Appeal Decision

Appeal Ref: APP/C3810/D/25/3362664

1 Elmer Court, Elmer, Middleton-on-sea, West Sussex PO22 6JT

- The appeal is made under section 78 of the Town and Country Planning Act 1990 (as amended) against a refusal to grant planning permission.
 - The appeal is made by Mr & Mrs Baritsch against the decision of Arun District Council.
 - The application Ref is M/100/24/HH.
 - The development is single storey rear pergola and first floor rear balcony with sliding doors.
-

04 REAR (SOUTH) ELEVATION:

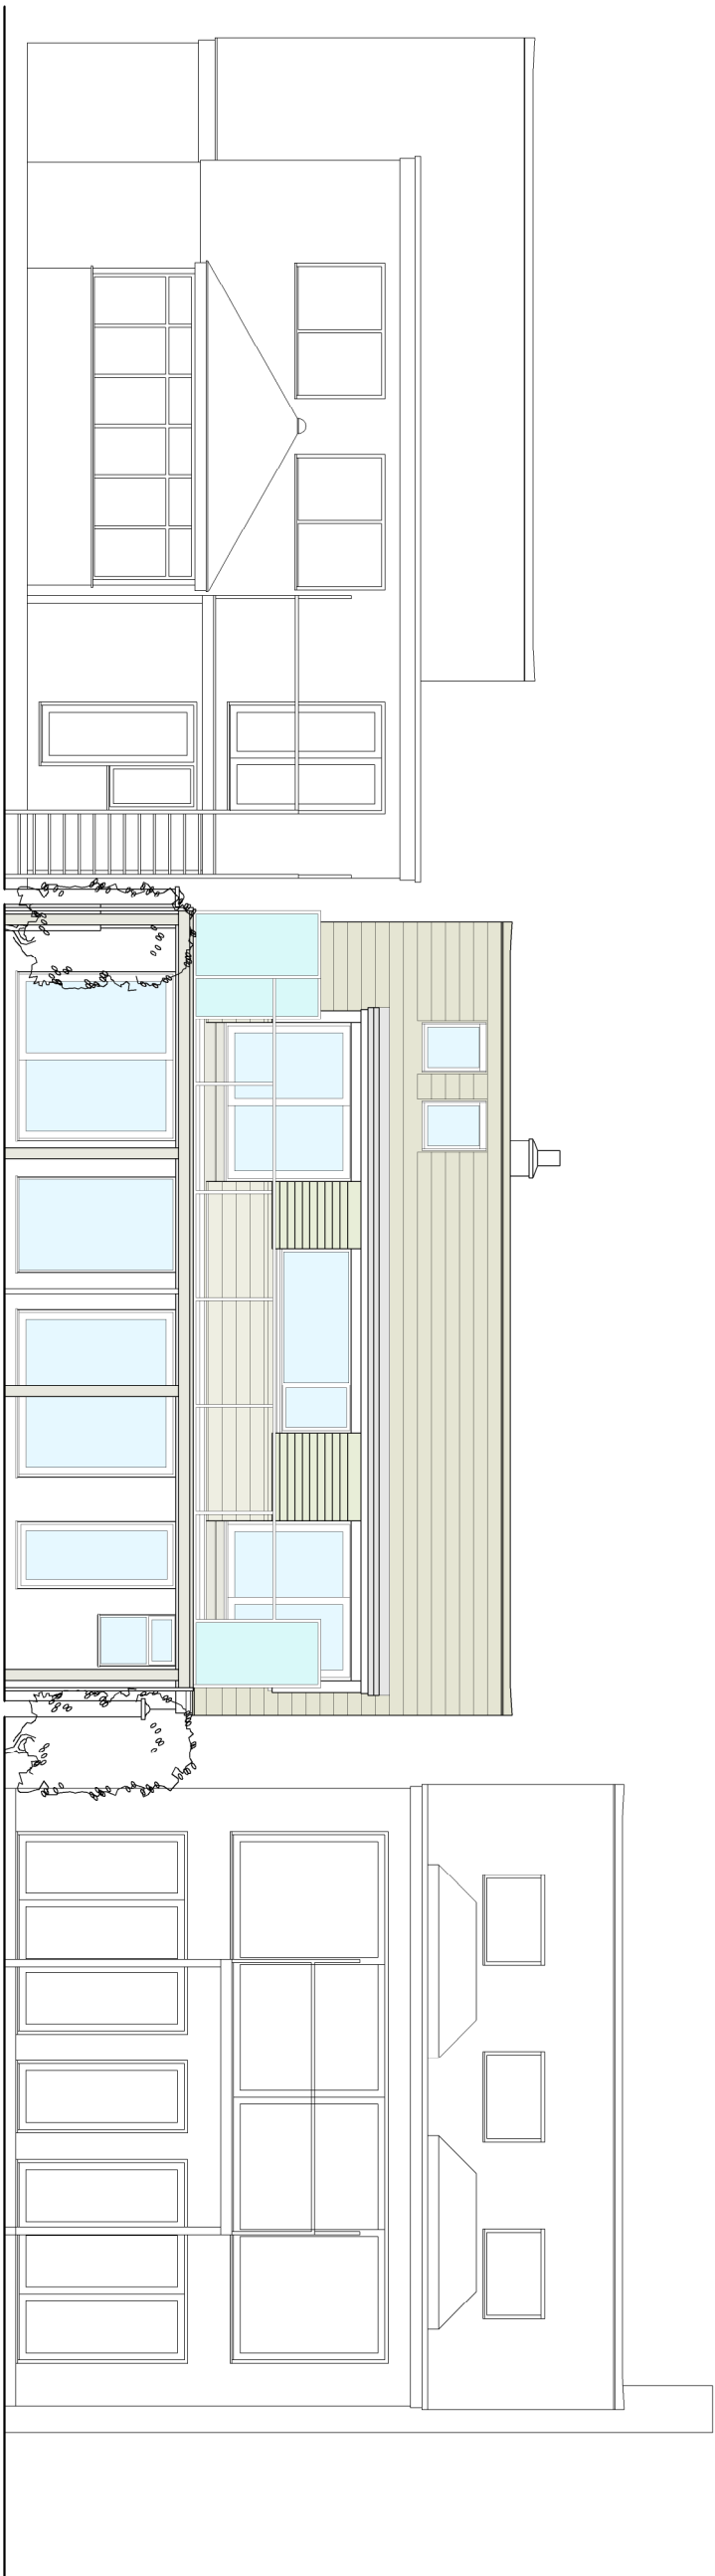
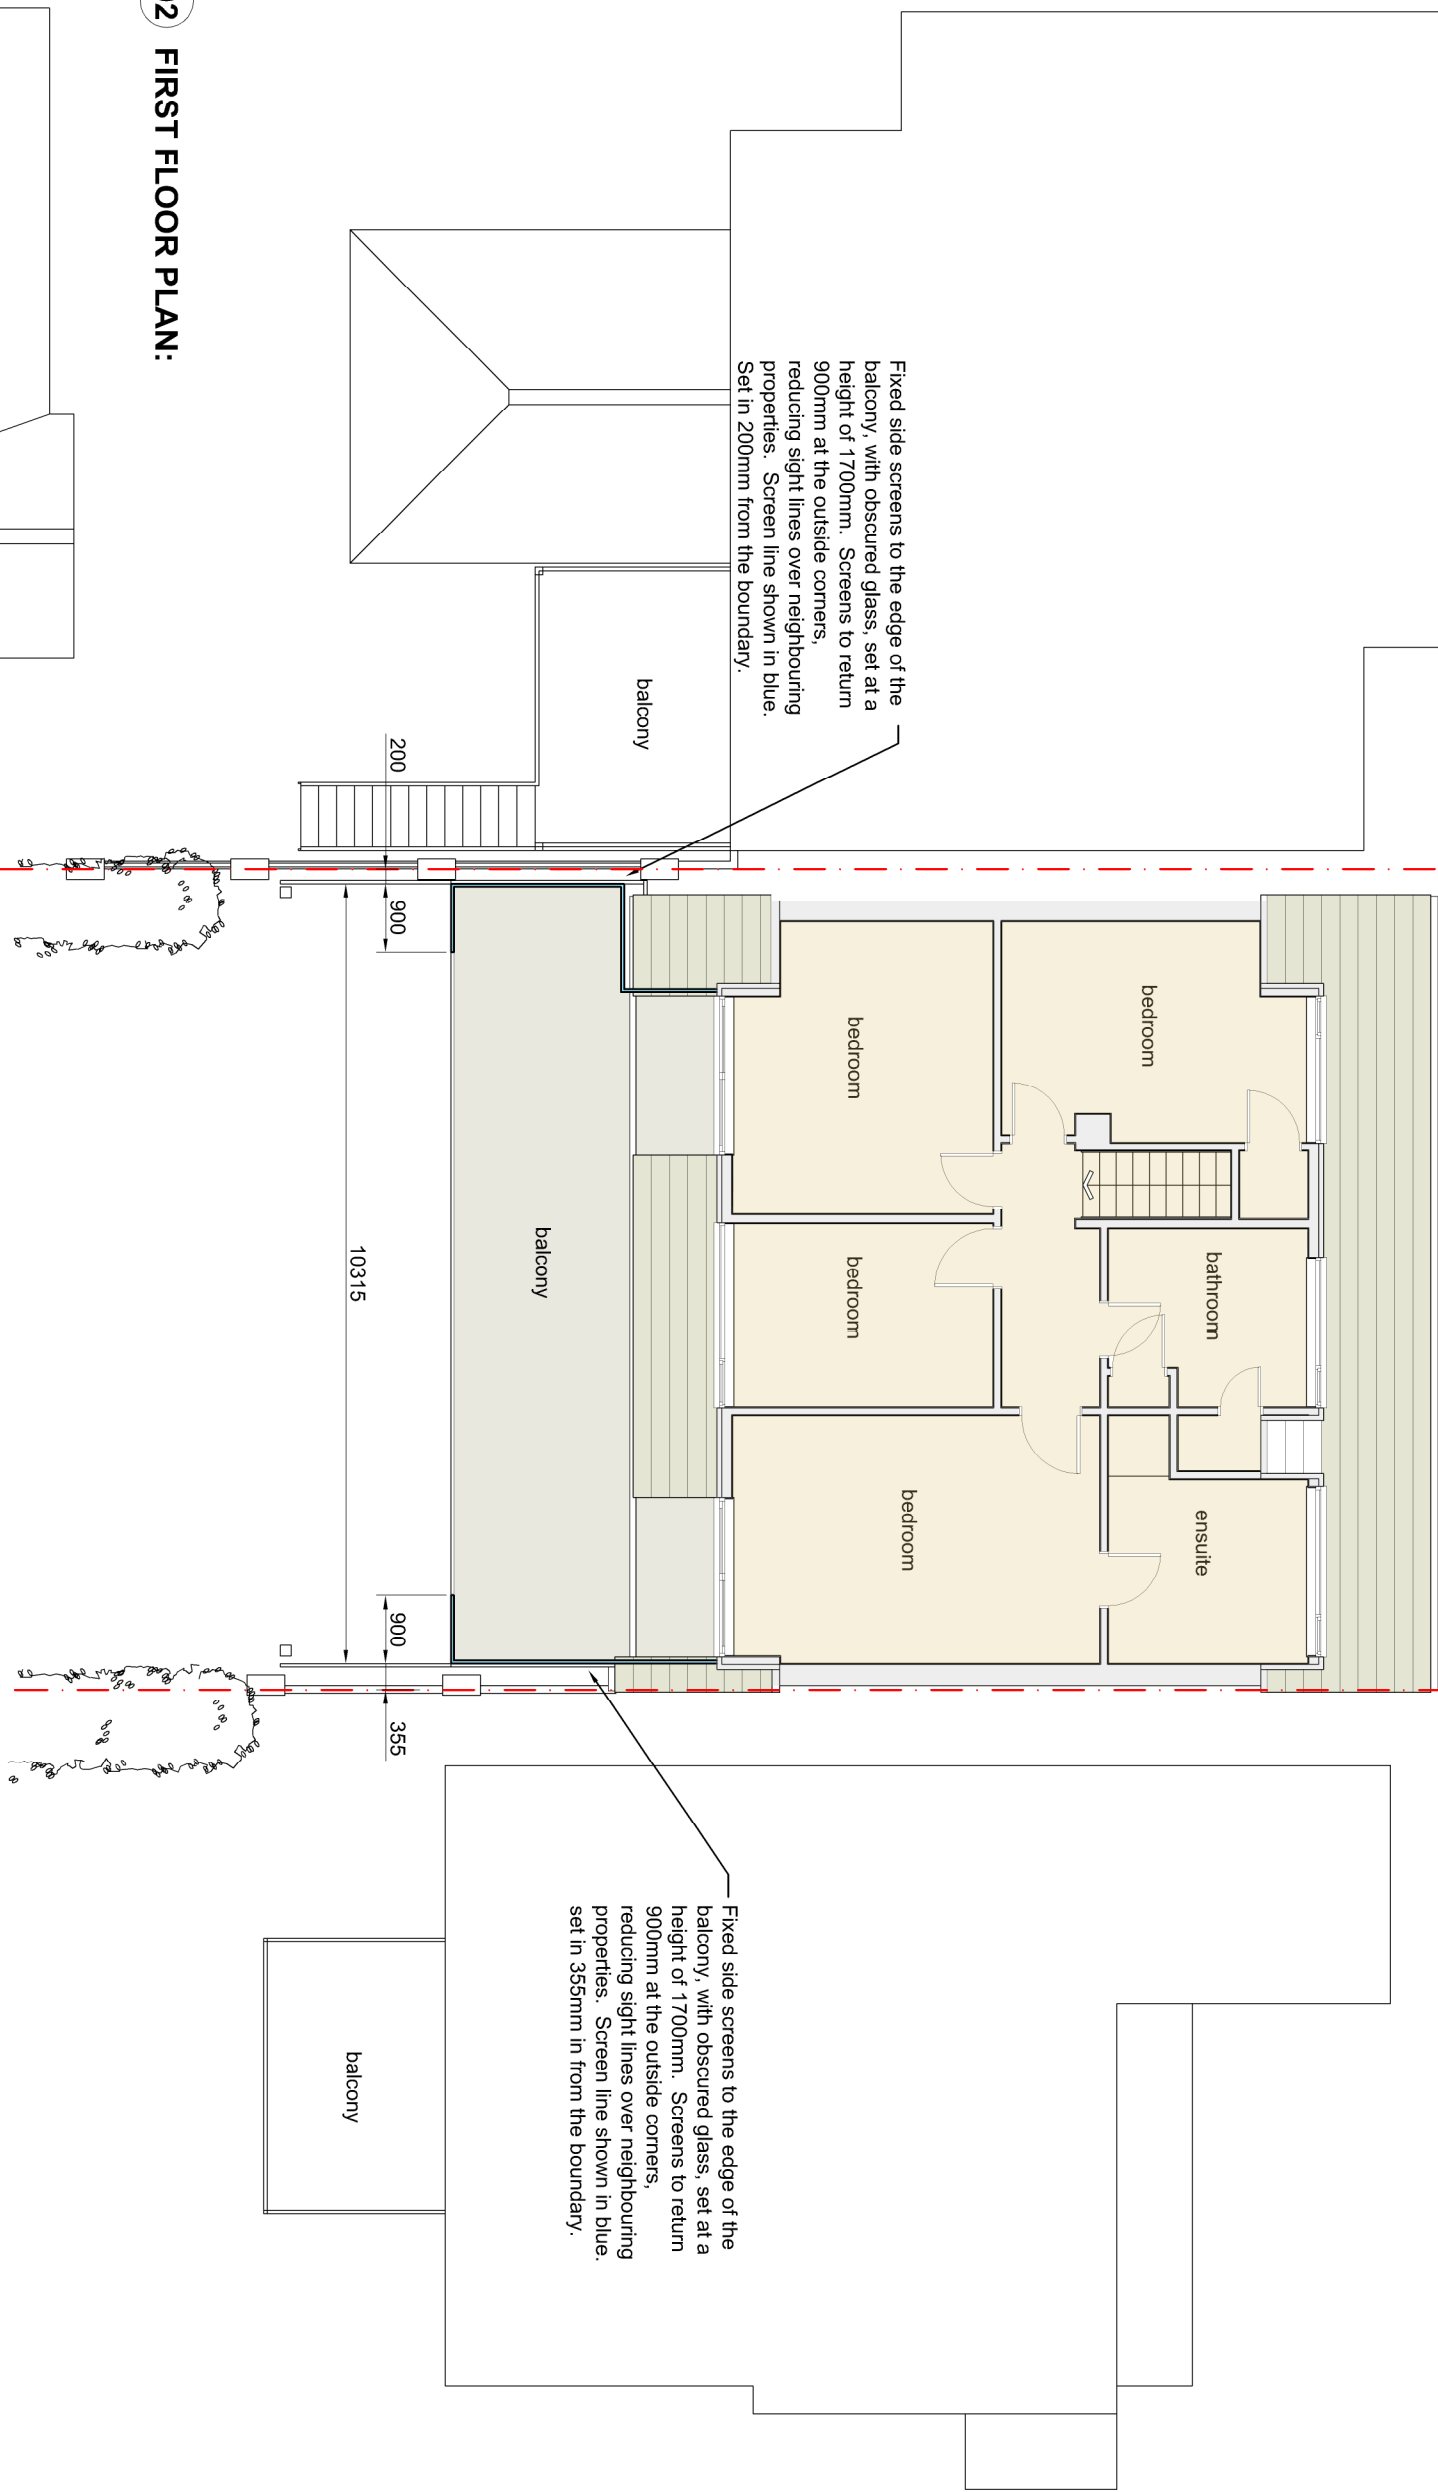
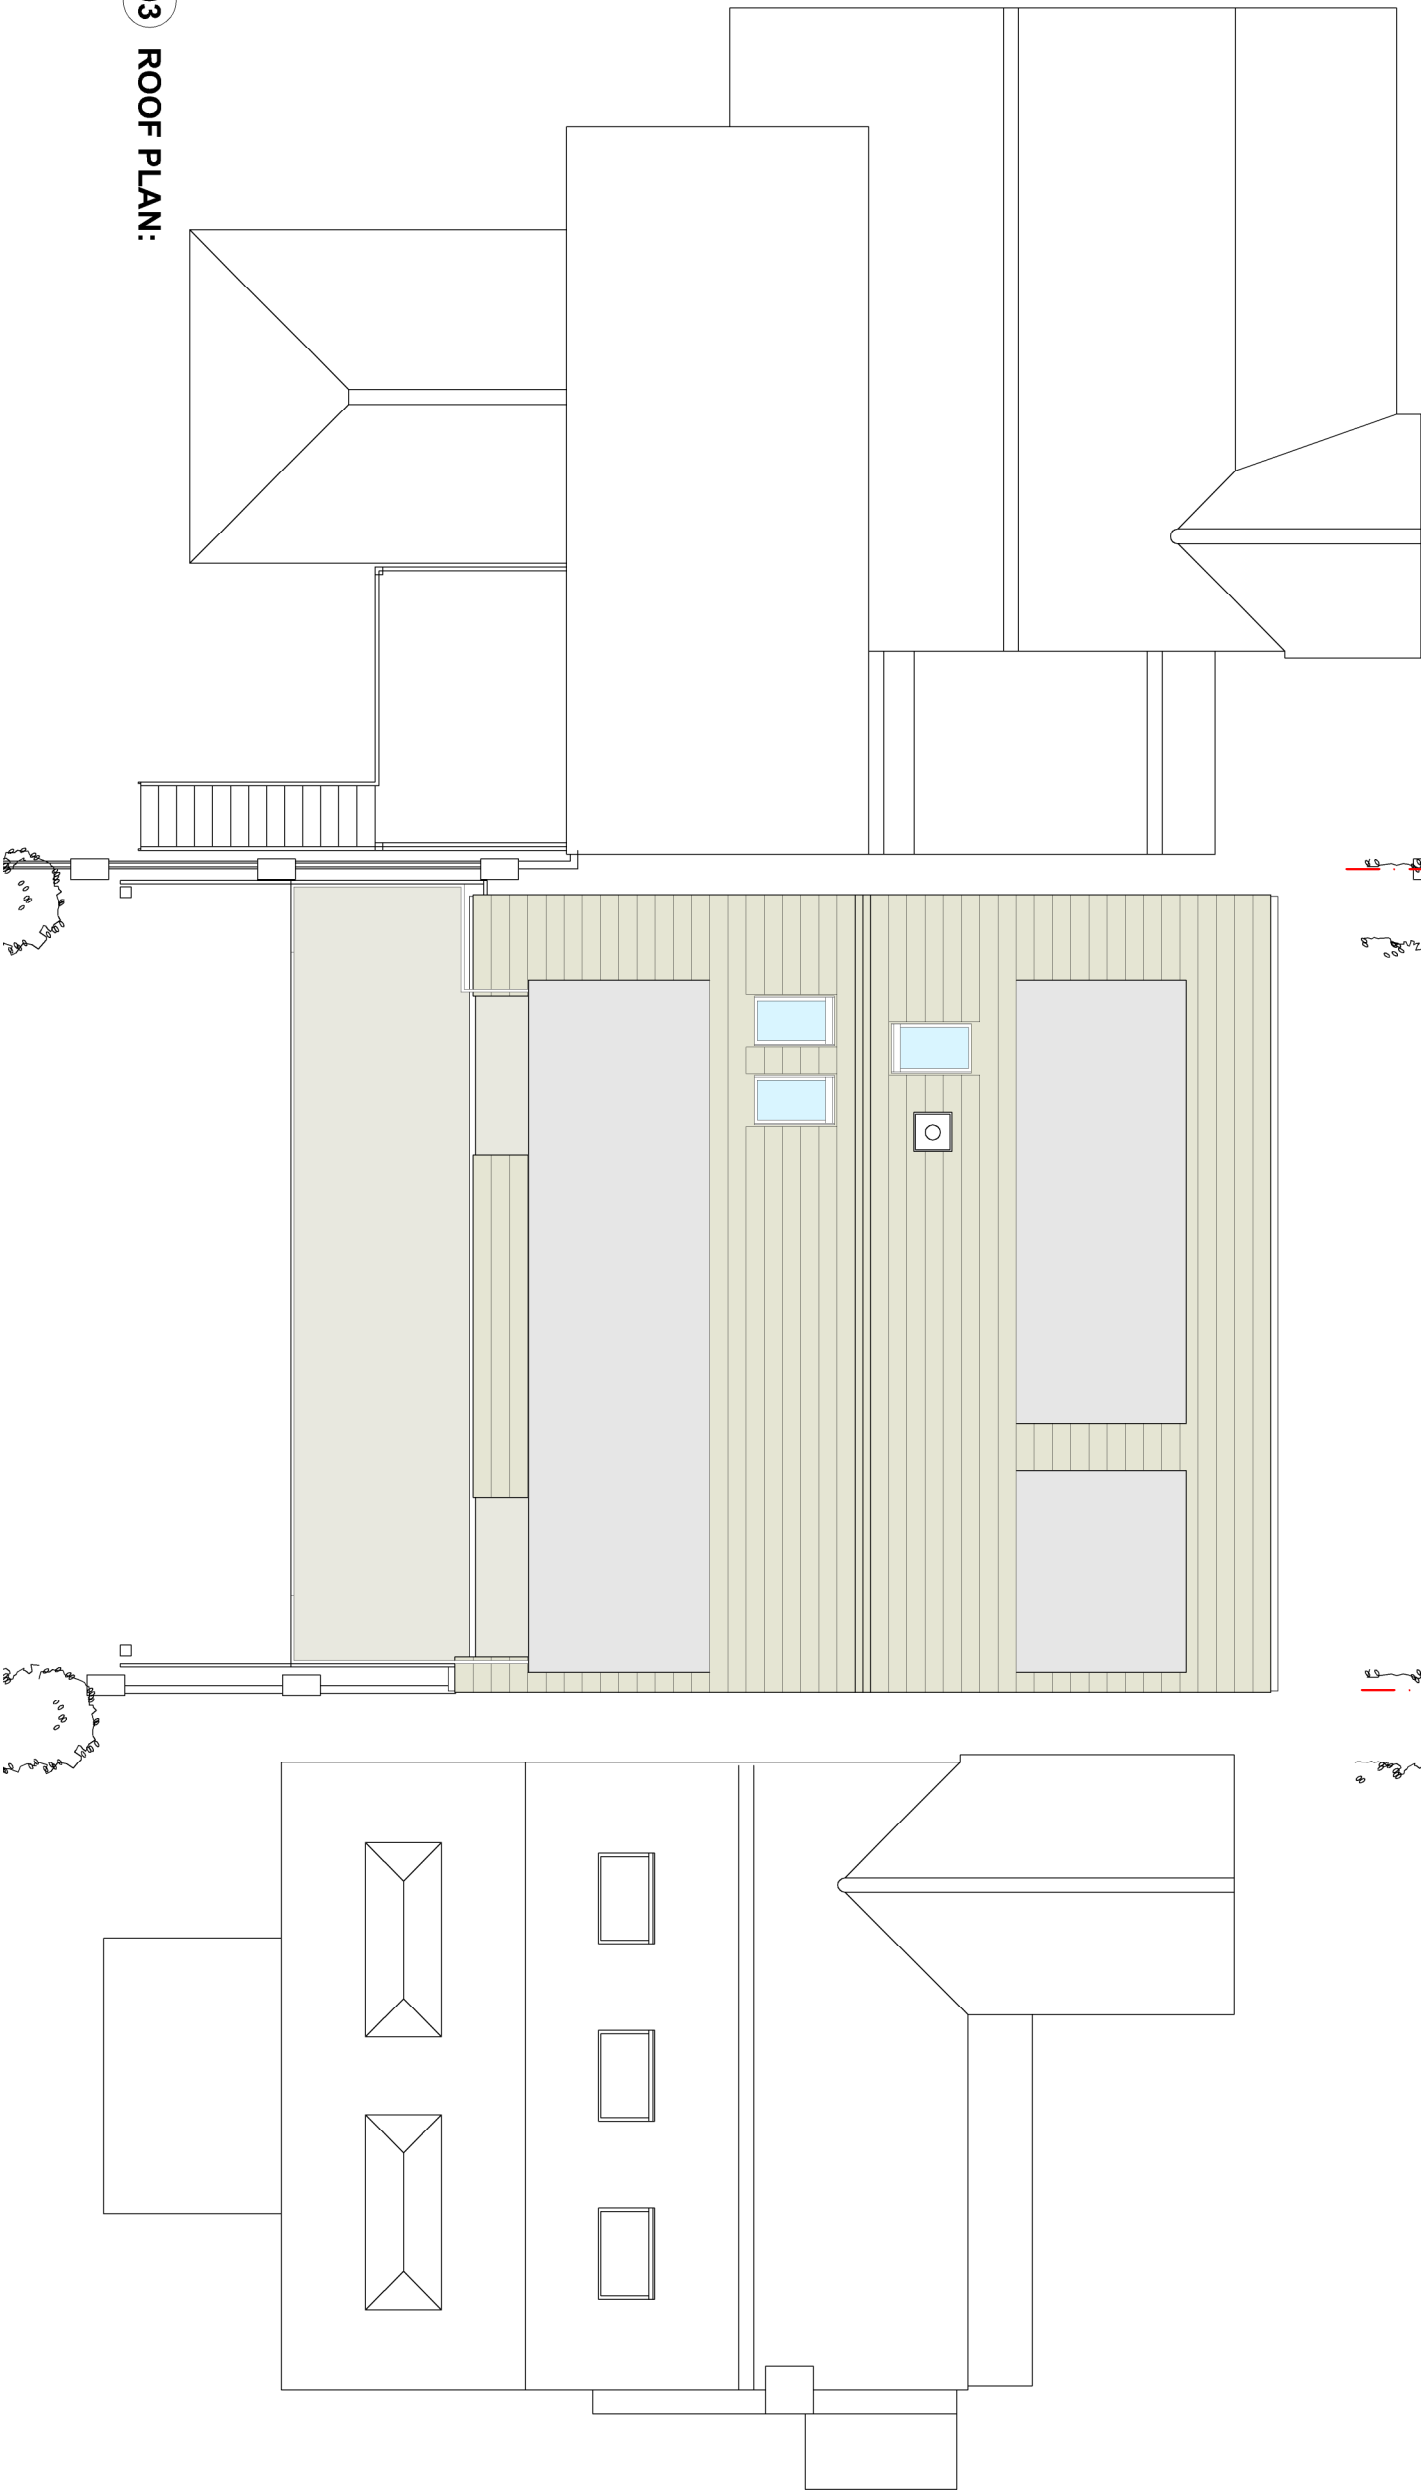
5. The appeal site lies on the southern side of Elmer Court and comprises a detached dwelling with its rear elevation facing the beach. The development includes a full-width single-storey balcony and pergola constructed from oak beams and timber planks, with sliding doors installed to the property at the rear at first floor. While the balcony and pergola have been erected, the balcony timber screen and railings remain incomplete.
6. From my site visit, I observed other full-width balconies at single-storey height in the area. However, these were either lightweight metal structures with slender

posts or positioned atop of rear extensions, appearing more integrated and visually sensitive. In contrast, the appeal scheme, due to its extensive use of timber, appears bulky and dominant.

7. The proposed pergola structure, although described as a pergola, does not reflect the typical open-roof form associated with such features. Instead, the roof of the pergola is fully timbered and closely resembles the balcony in both design and construction. Its solid and enclosed appearance contributes to a greater sense of mass and bulk, which is visually at odds with the character of the property.

8. The combined massing and materials of the balcony and pergola result in an incongruous addition that overwhelms the rear elevation of the host property. While balconies are a recognised feature of the area, the appeal development lacks the design subtlety seen in other nearby examples and fails to respect the character of the host property.

12. It was evident that the timber privacy screen installed at ground floor level extends above the existing boundary wall and rises beyond the height of a standard 1.8 metre close board fence. This creates a tall and visually solid structure that dominates No. 2 Elmer Close. The height and bulk of the screen result in a pronounced sense of enclosure, which I consider to be harmful and overbearing to the garden and rear-facing rooms of that property

13. As the pergola does not reflect the typical open-roof design and sides as expected of such structures, its solid timber construction, lack of openness, and projection beyond the rear elevation of No. 2 Elmer Close results in an overbearing relationship with this neighbouring property. This causes an unacceptable impact on the living conditions of its occupiers.

15. From the appeal balcony, I observed views into the garden of No. 2 Elmer Close and No. 4 The Hard. While this raises concerns regarding overlooking, I find that appropriate screening, such as obscure glazing could mitigate these impacts. Such
